Ask for:	Sharon Horner
Telephone:	01832 742001
Planning Services	
Our Ref:	NE/21/01338/FUL
Your Ref:	PP-10175142
Date:	10 September 2021

Proposal: **New storage building comprising insulated rooflights, roller shutter door, 2 personnel doors, fire escape staircase leading down from mezzanine floor located in the first bay at Auto Spares and Salvage Ltd Station Road Raunds Northamptonshire NN9 6BX.**

**TITLE**  
 FLOOR PLANS - PLANNING DRAWING

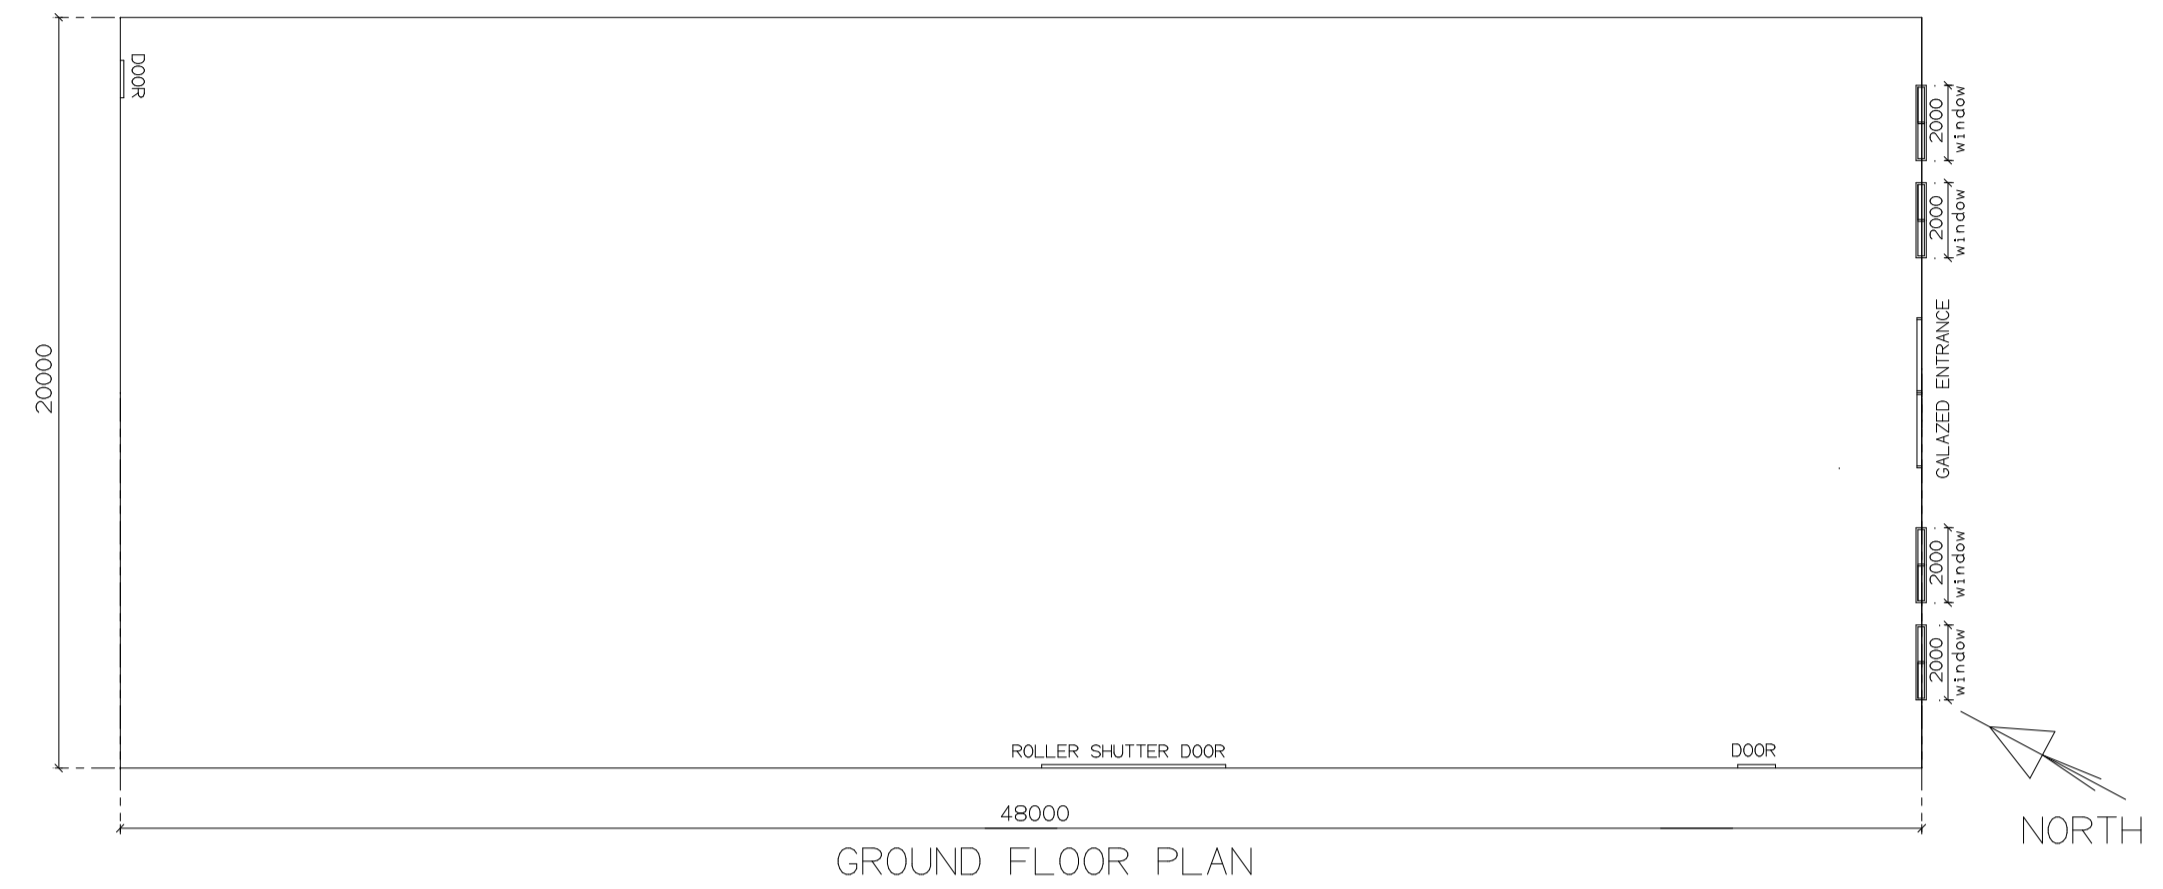
1. Thank you for the drawings submitted with your application, although you have provided the proposed ground floor plan, not all windows/doors and details are shown on this current floor plan:
 - There are windows shown on the elevation, at ground floor level either side of The glazed entrance door, along with numerous windows shown at first floor level.
 - A fire escape door with stairs shown on one elevation, along with roof lights at The upper/2nd floor
 - The elevation showing the roller shutter door, has a window at first floor level and roof lights at the upper/2nd floor

- Amended ground floor plan, first floor plan, second floor/roof plan, showing the omitted details as listed above.
